29 November 2019

Our Ref: R/2018/32/B  
File No: 2019/606327

**Advice on Response to Submissions – Adaptive Reuse of the Royal Hall of Industries (SSD – 9726)**

Trees for Removal - 4
Trees to be Retained and Protected - 56
Proposed Trees on Ground Floor - 23

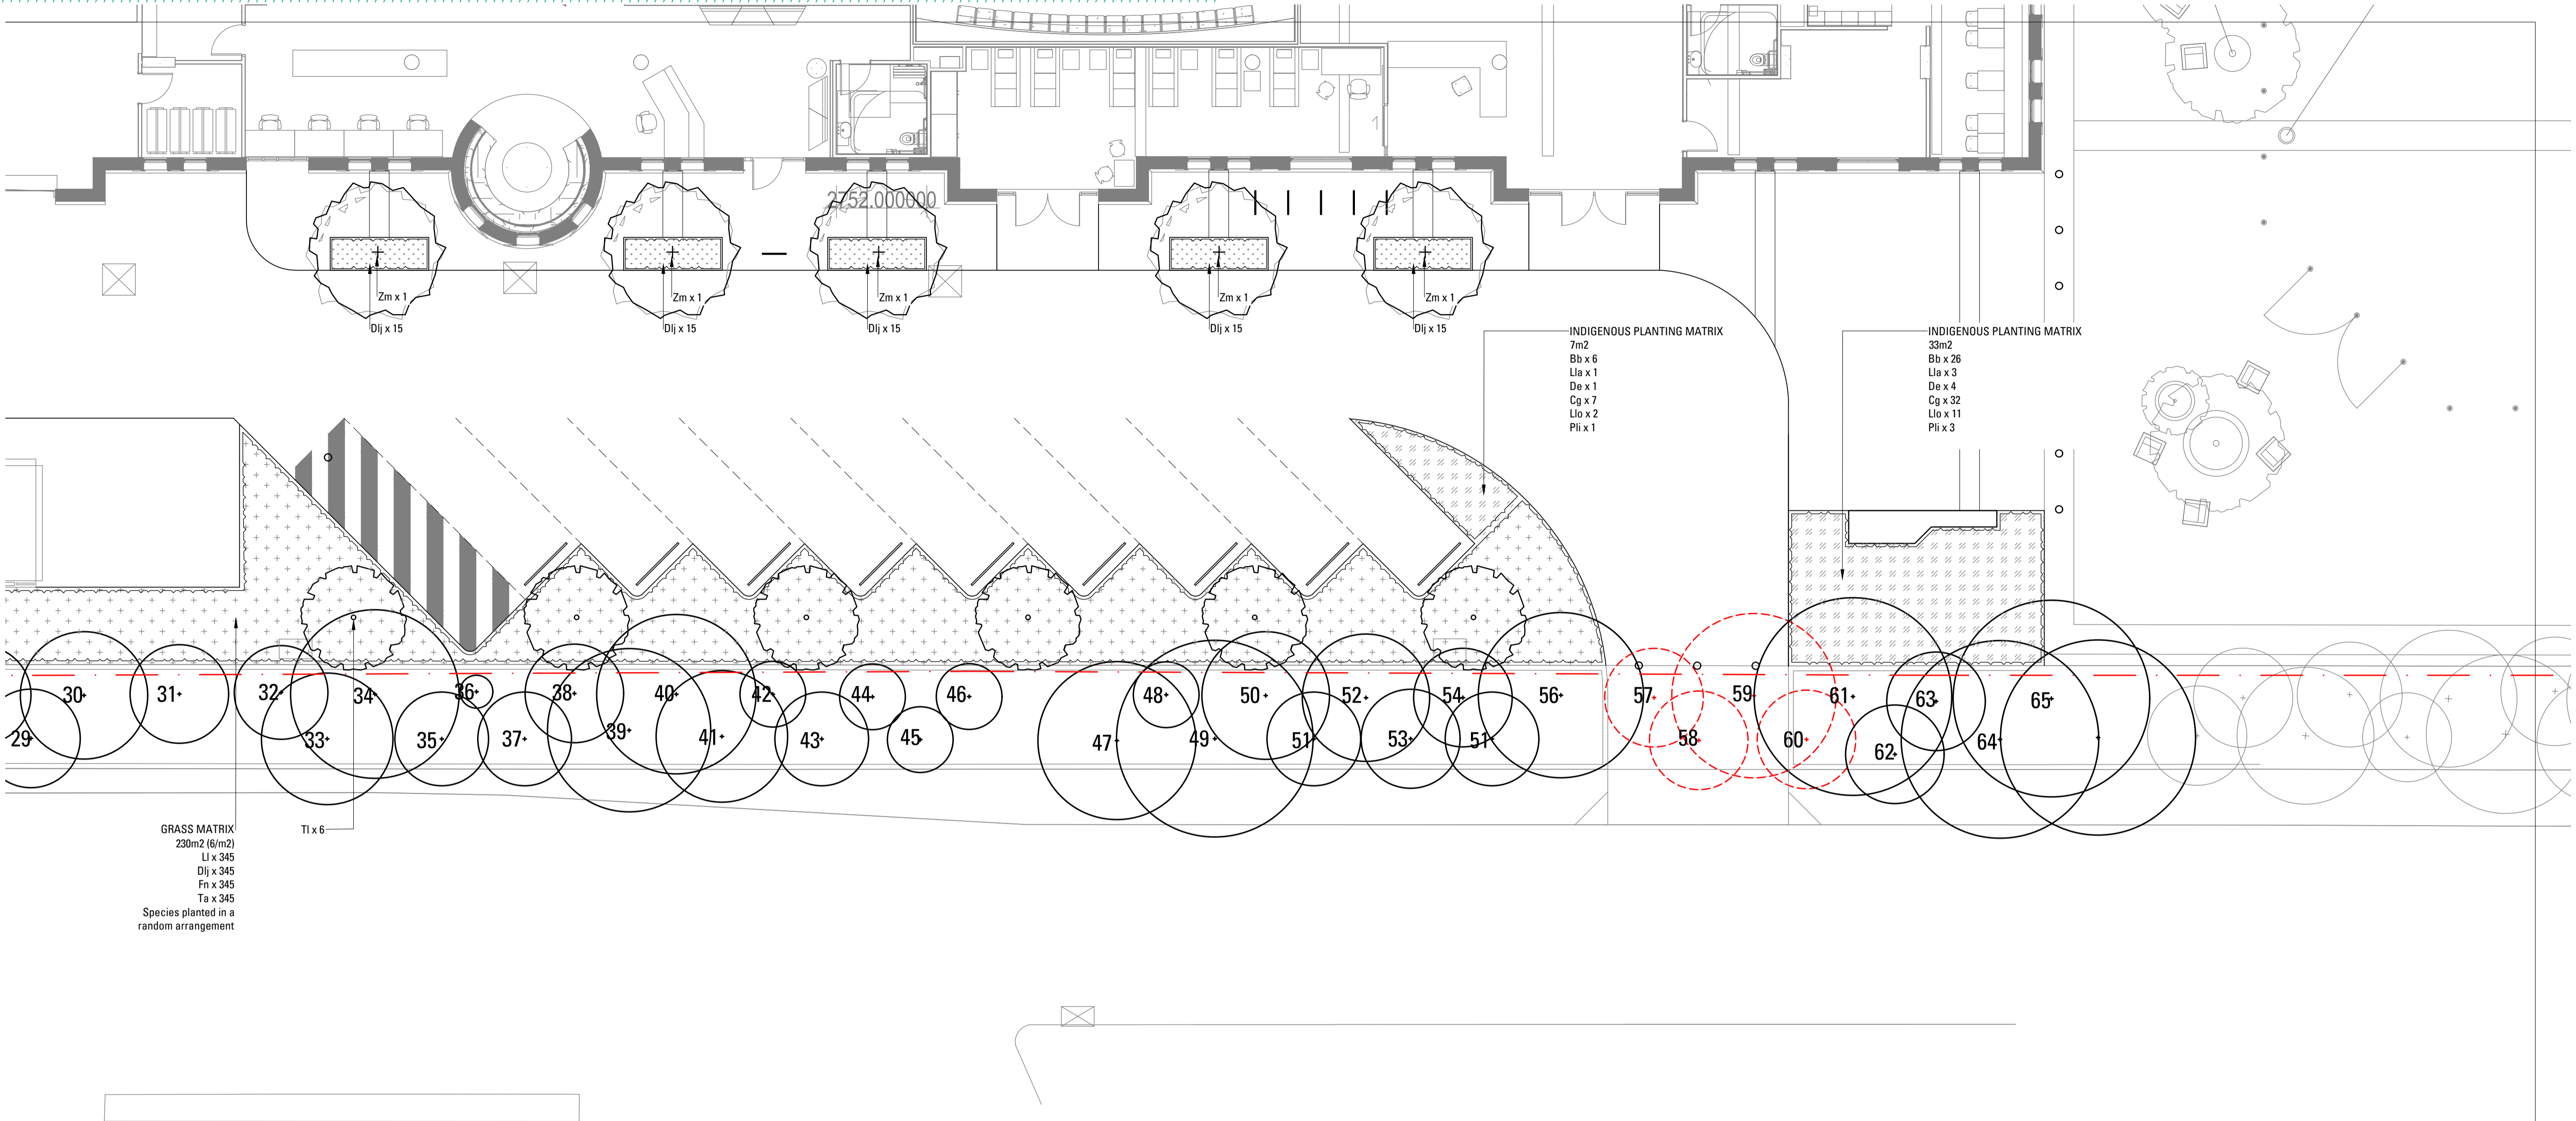
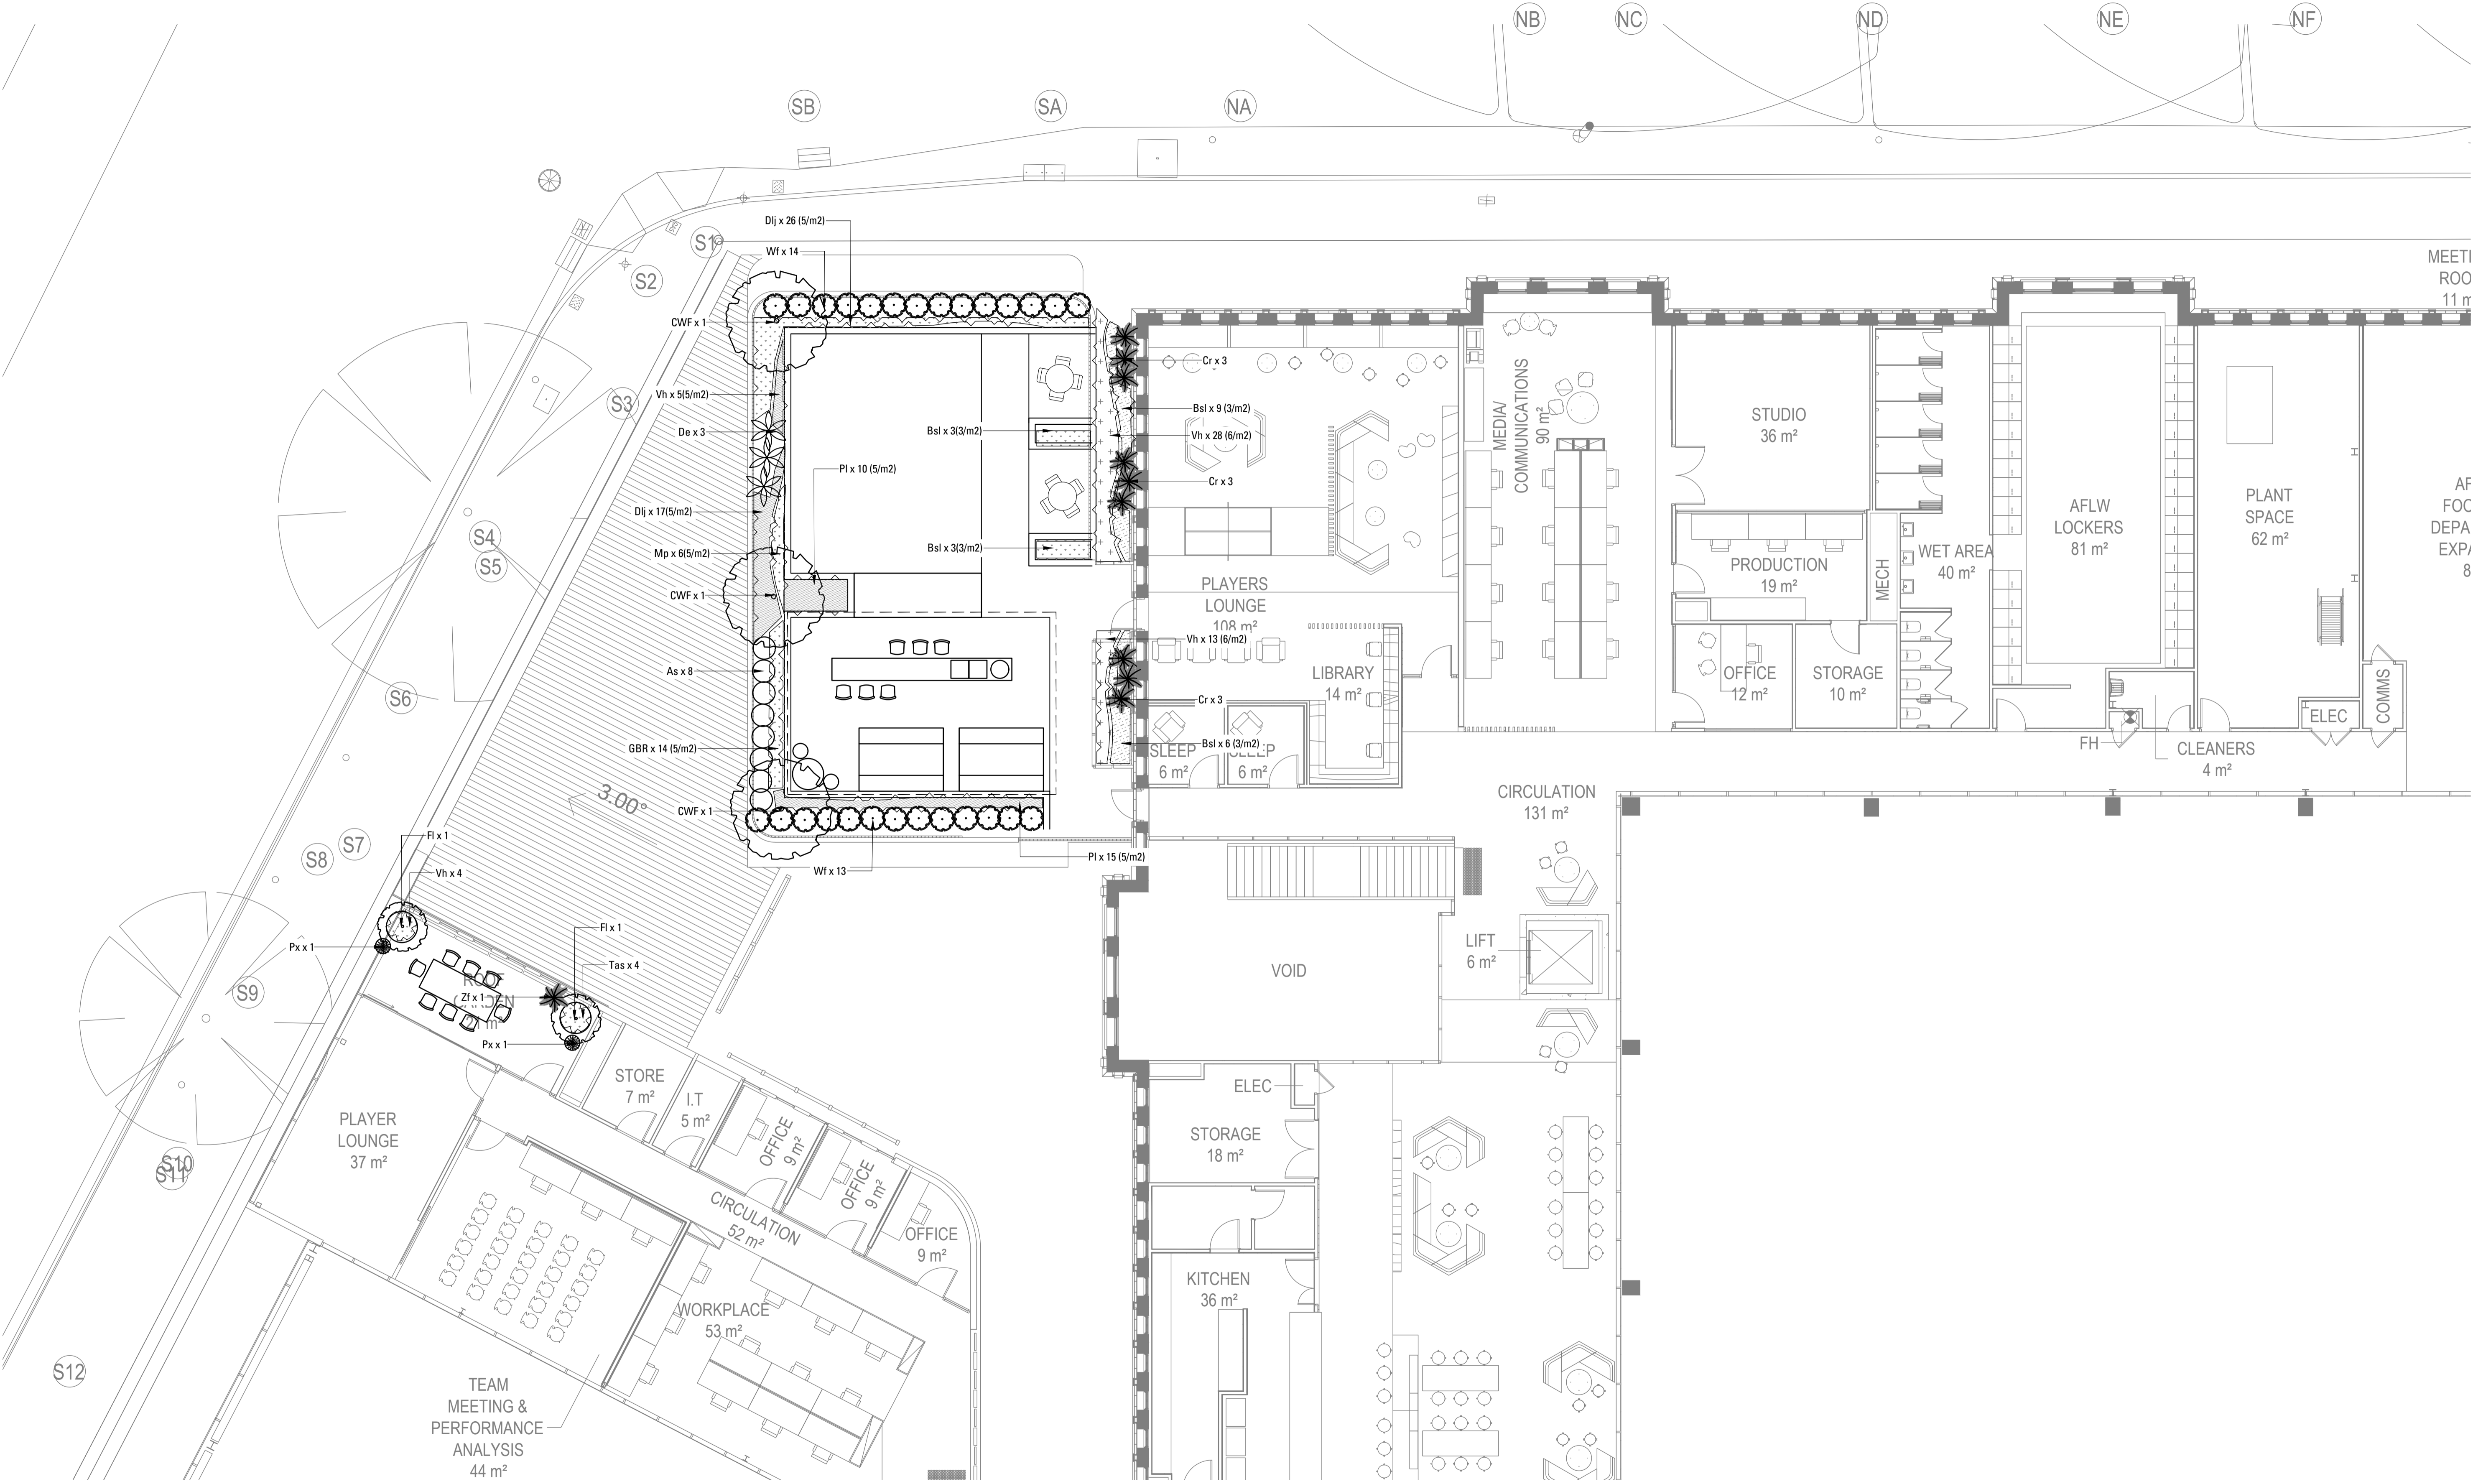
The City reiterates that Trees 58, 59 and 60 on Errol Flynn Boulevard **must be retained**. The trees are semi mature to mature healthy trees with a medium landscape significance rating. The trees form part of a group of planting along Errol Flynn Boulevard that make a positive contribution to the landscape.

Further, the proposed north-eastern driveway cross over for the car park exit will have a significant encroachment within the TPZ of Trees 56 and 61. As an alternative, it is suggested that the proposed north-eastern driveway crossover be amended to utilise existing crossovers or be relocated so that a section of trees with lesser value, size and health be removed instead. As such, consideration should be made to Trees 42-46, which are of less significance and remove Tree 43 and 45.

The Landscape Plan, prepared by Arcadia, has suggested planting of 26 trees of mixed species. The majority of the selected tree species will be under 10 metres in height at maturity. The proposed tree species of *Zelkova serrata* 'Musashino' should be amended to native tree species that is in keeping with the surrounding vegetation. Further, the proposed tree species selection should be amended to include a greater number of trees that will grow greater than 15 metres in height and meet the City's canopy coverage requirement of 15%. The southern landscaped area (grass) between the existing palm trees and the new netball court has the potential for medium sized tree planting.

04 ROOF TERRACE - PLANTING CONDITION - TREE SECTION
501 SCALE 1:10

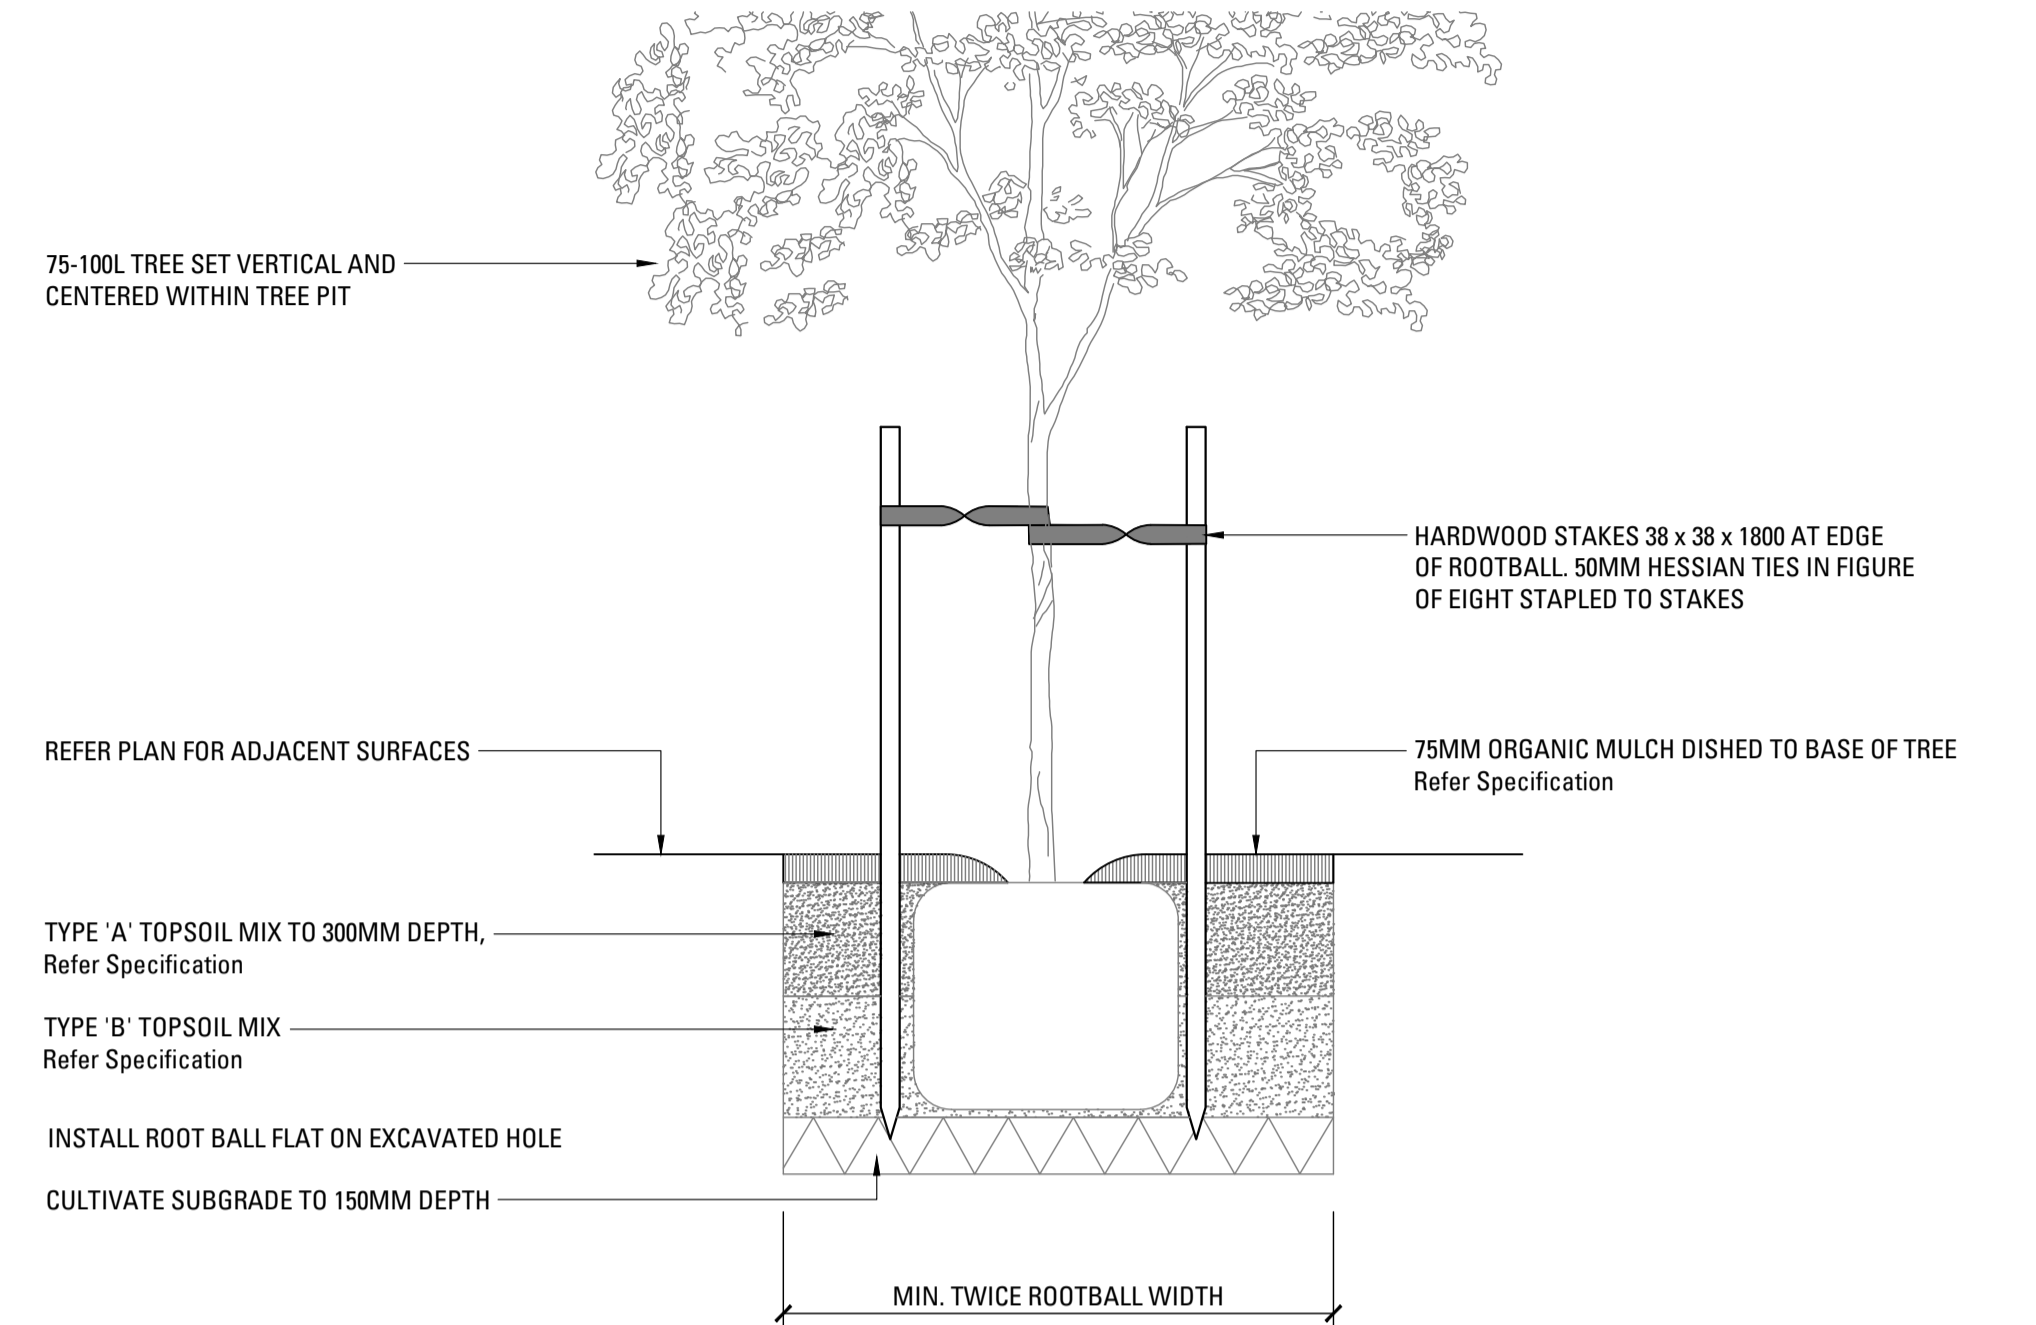
The Landscape Specification states that on-slab areas will be cover the bottom of the planter with a geotextile turned up to 300mm and taped to the side of the planter. This is likely to result in turning and circling of the roots, which is likely to impact the trees future growth and structural condition.
